EN010117: Application by Rampion Extension Limited for the Rampion 2 Offshore Wind Farm

Horsham District Council response to The Examining Authority's Draft DCO issued on 18th June 2024

Deadline 5: HDC Response and Information Requested to the Examining Authority's schedule of proposed changes to the draft Development Consent Order (dDCO) [PD-013]

Oakendene Onshore Substation – Indicative Landscape Plan

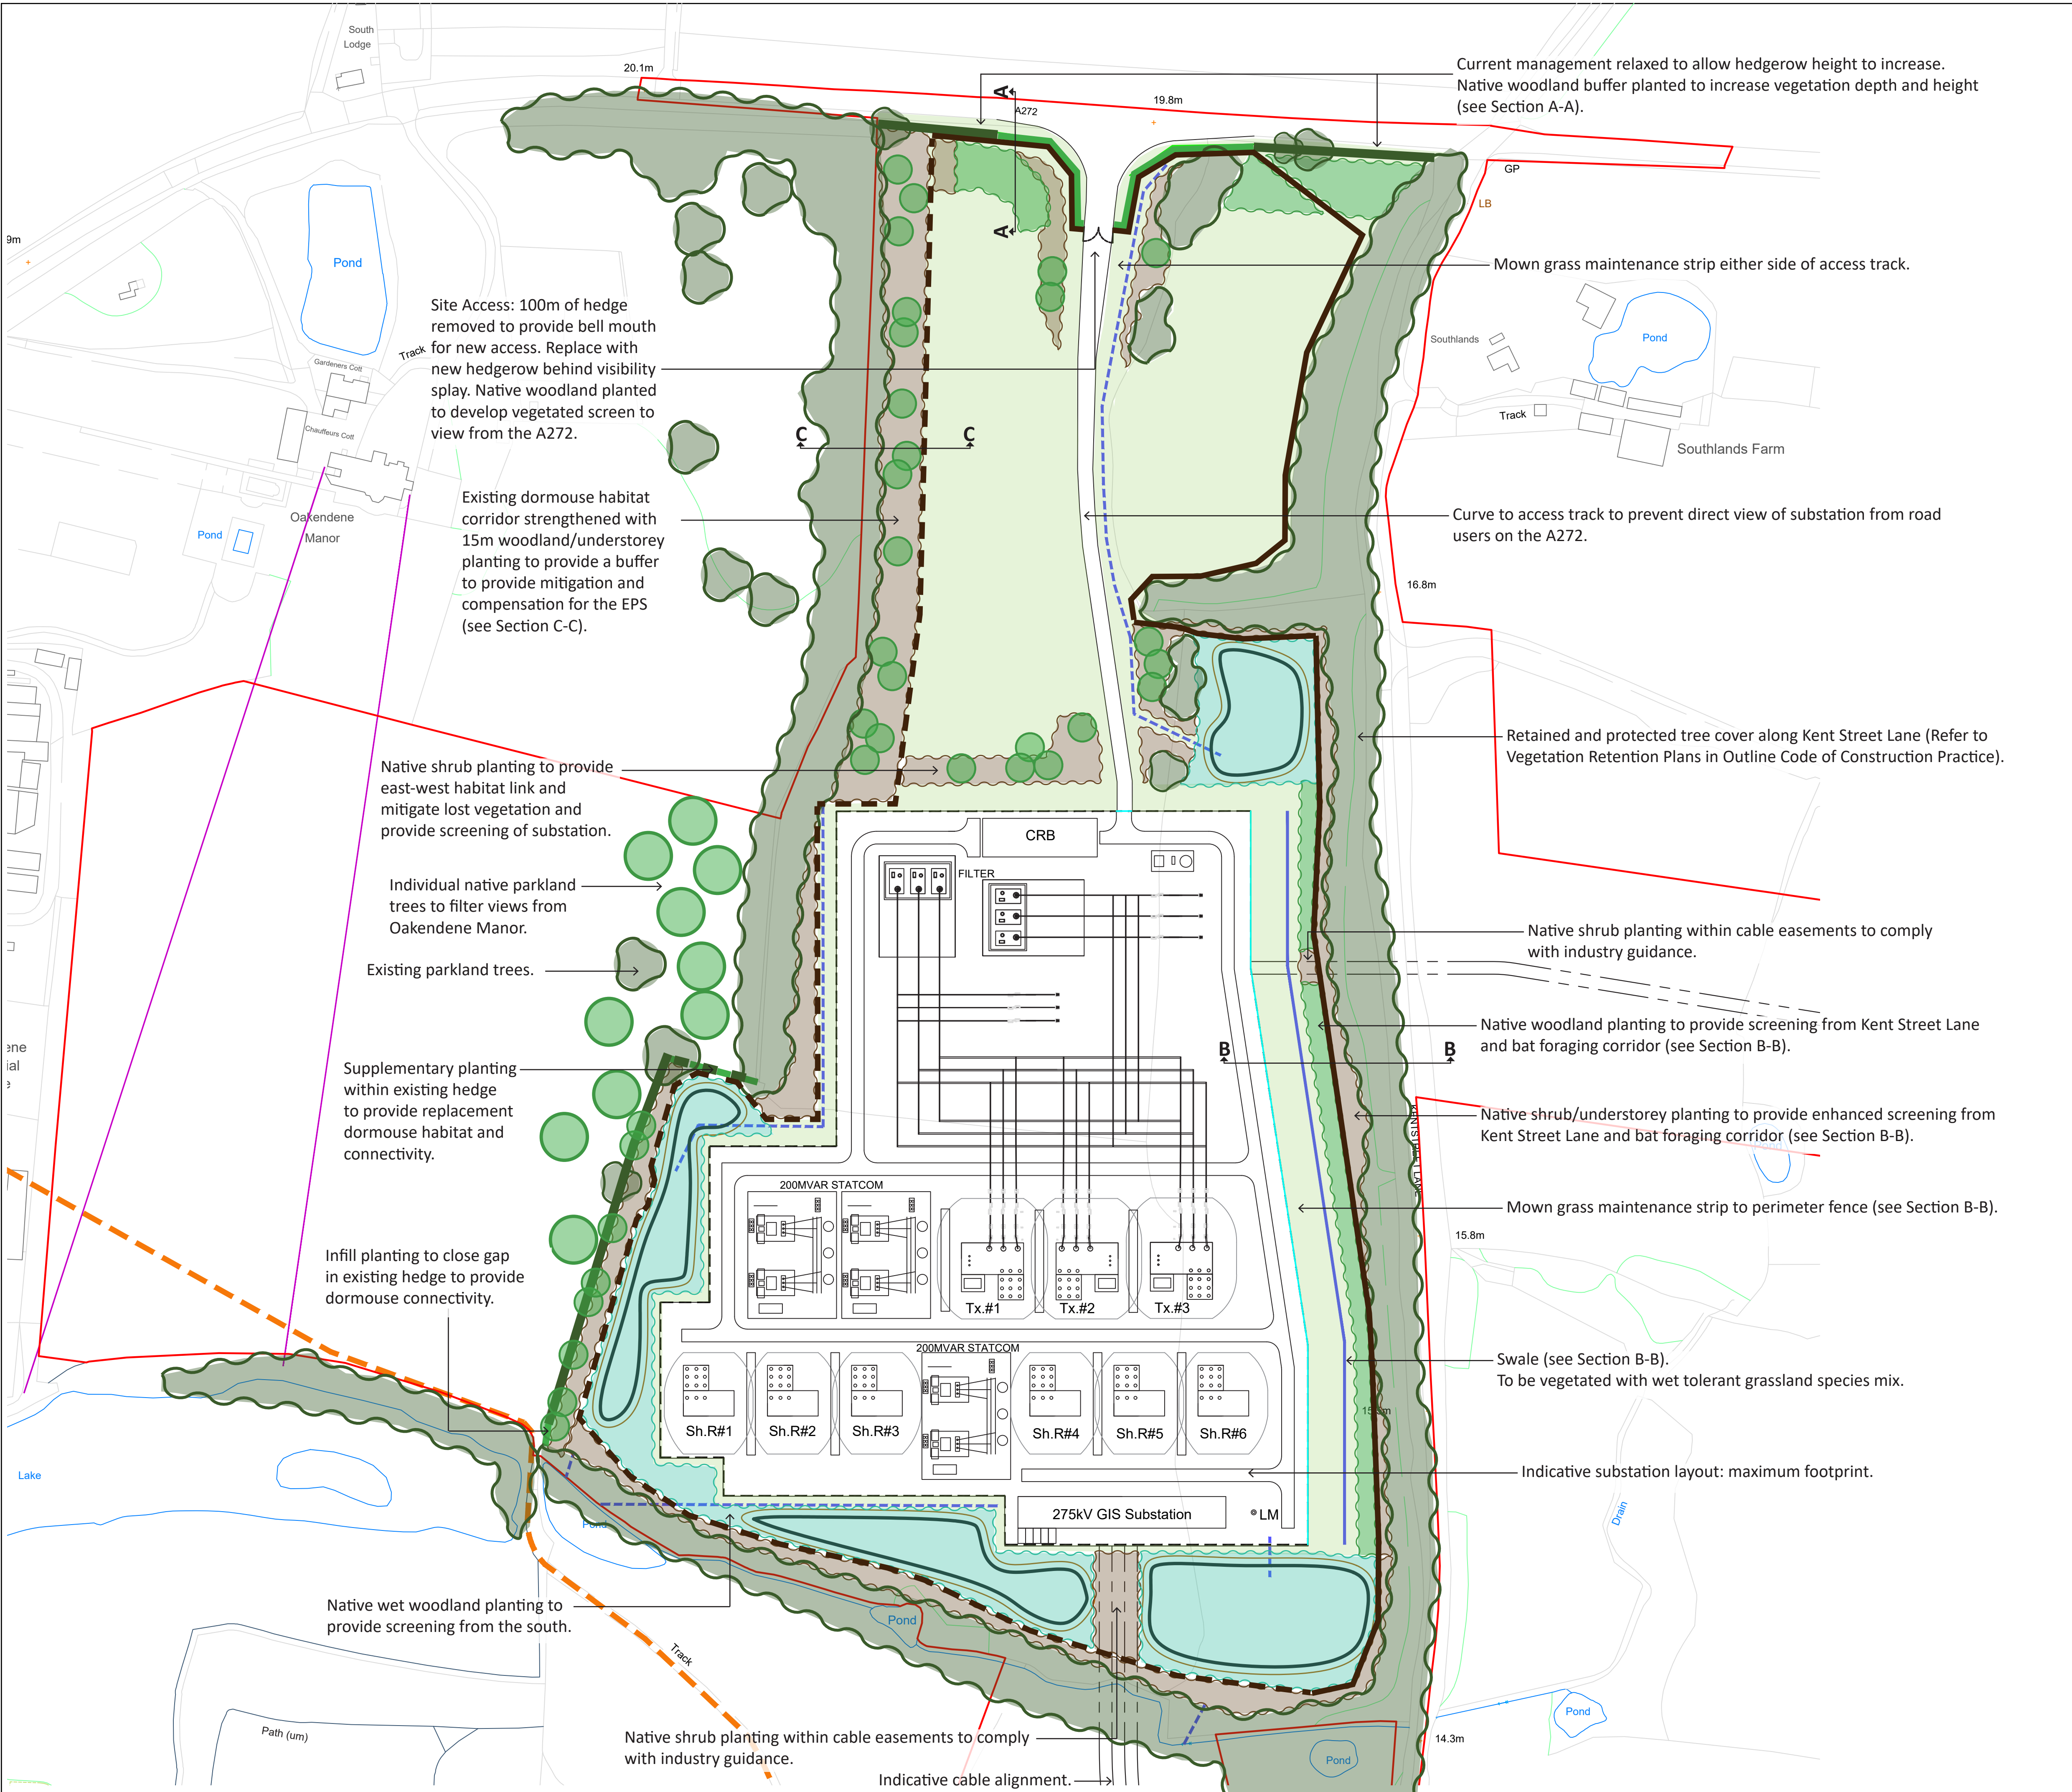
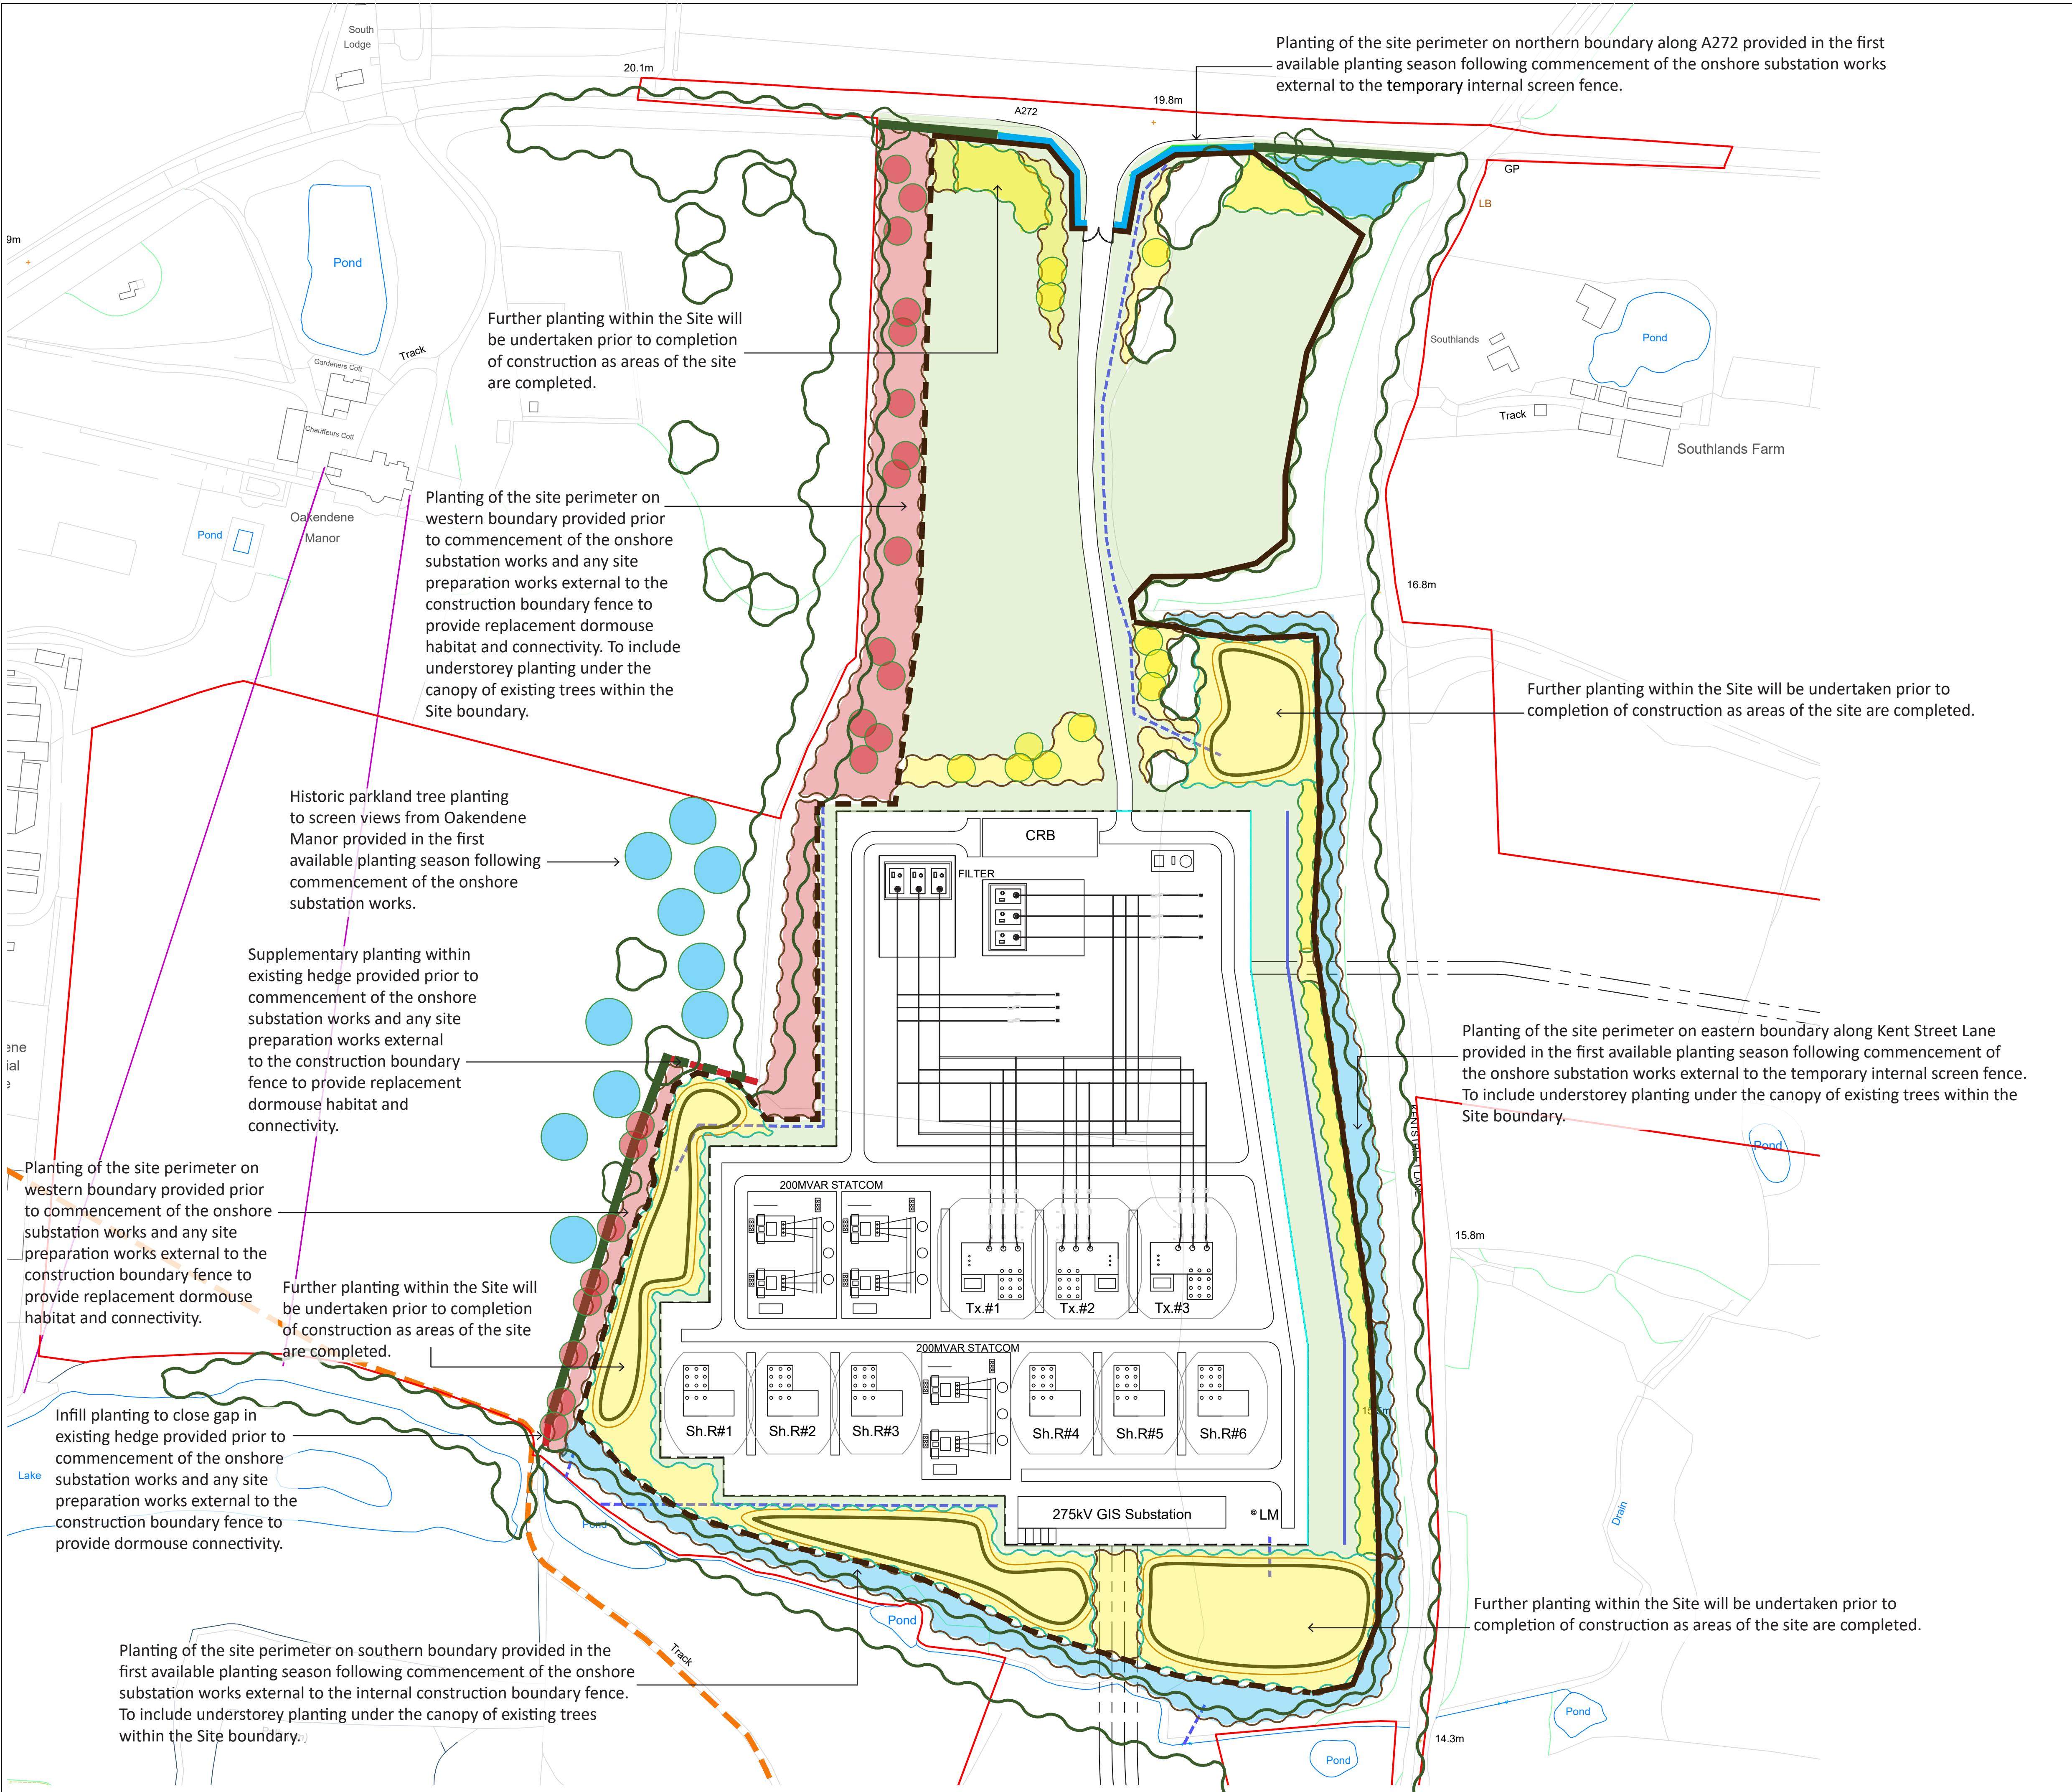
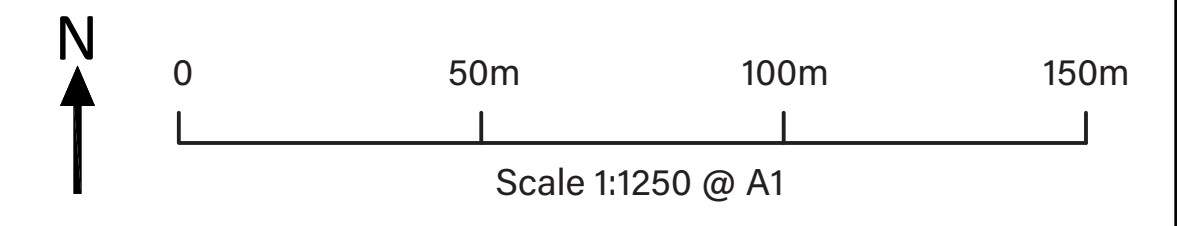
No.	Reference	ExA's Reasoning	HDC RESPONSE
8.	Schedule 1, Part 3, Requirement 8(1) Site-Specific Plan for the Detailed design approval onshore substation at Oakendene	<p>The ExA considers that the submission and approval of an overarching site-specific plan for works in the area of Oakendene Substation is necessary, as at this stage of the Examination there are many outstanding areas of concerns which will need to be addressed. These include:</p> <ul style="list-style-type: none"> • The safe construction of the works is dependent on the detailed development by the Applicant of a complex traffic management strategy involving HGV movements along the A272 and in and out of Oakendene Compound, Oakendene Substation Site and Kent Street and its approval by West Sussex County Council as Highway Authority. • The use of Kent Street a single track lane will in particular require careful detailed planning in order to facilitate the safe movement of private vehicles, pedestrians, cyclists and equestrians in combination with construction traffic; • The detailed design of the permanent access to Oakendene Substation; • Details of the vegetation loss, retention and replanting at the Oakendene site; • Details of drainage including how it will work with the landscaping. <p>The ExA considers the suggested changed to Requirement 8 would ensure a comprehensive site-specific plan for the Oakendene substation site is therefore necessary.</p>	<p>HDC supports the ExA's reasoning on securing an site-specific plan for the detailed design approval of the onshore substation at Oakendene.</p> <p>Whilst the applicant has made supportable changes to Requirement 8 over the course of the Examination, based on the submission evidence, the successful delivery of landscaping at the Oakendene site remains a concern by HDCm in particular how it would work with the drainage.</p> <p>It was also evident from the ISH2 held in May 2024 that more finer grain evidence is required to be undertaken by the applicant on the traffic management strategy and associated design work for access for this site area, including on reinstatement measures, such as passing bays along its Kent Street and widening of the road junction with the A272, to mitigate identified harms.</p> <p>It is unclear from the submission at deadline 4 if all control documents are informed by the proposed traffic management strategy on Kent Street. For instance, if the Outline Landscape and Ecology Management Plan insert the reinstatement measures along Kent Street. A holistic Site Specific plan for the detailed design of the substation at Oakendene would assist with resolving this.</p> <p>HDC suggests it would be clearer if at 8(1) as proposed, operational and maintenance water usage (which it is assumed refers to demonstrating water neutrality), be separated out from the (conventional) site surface/foul water drainage.</p>

<p>Additionally, HDC recommends insertion of the word sustainable to the site drainage is changed to <i>sustainable</i> drainage strategy as this component of the site design needs to work with the landscaping objectives. Both changes are detailed below.</p> <p>8.—(1) Works comprising Work No. 16 together with the associated Work No. 17, Work No. 18 and Work No. 19 (excluding any onshore site preparation works) must not commence until details of —</p> <p>(a) siting and layout;</p> <p>(b) scale and quantum of development and its uses;</p> <p>(c) existing and proposed finished ground levels;</p> <p>(d) landscaping;</p> <p>(e) access; and</p> <p>(f) external appearance, form and materials for any buildings structures and other infrastructure including boundary treatment;</p> <p>(g) a construction traffic plan illustrating the access and egress points, traffic routing and vision splays;</p> <p>(h) vegetation removal, retention and replanting; and</p> <p>(i) operational and maintenance water usage and</p> <p>(j) sustainable site drainage</p>
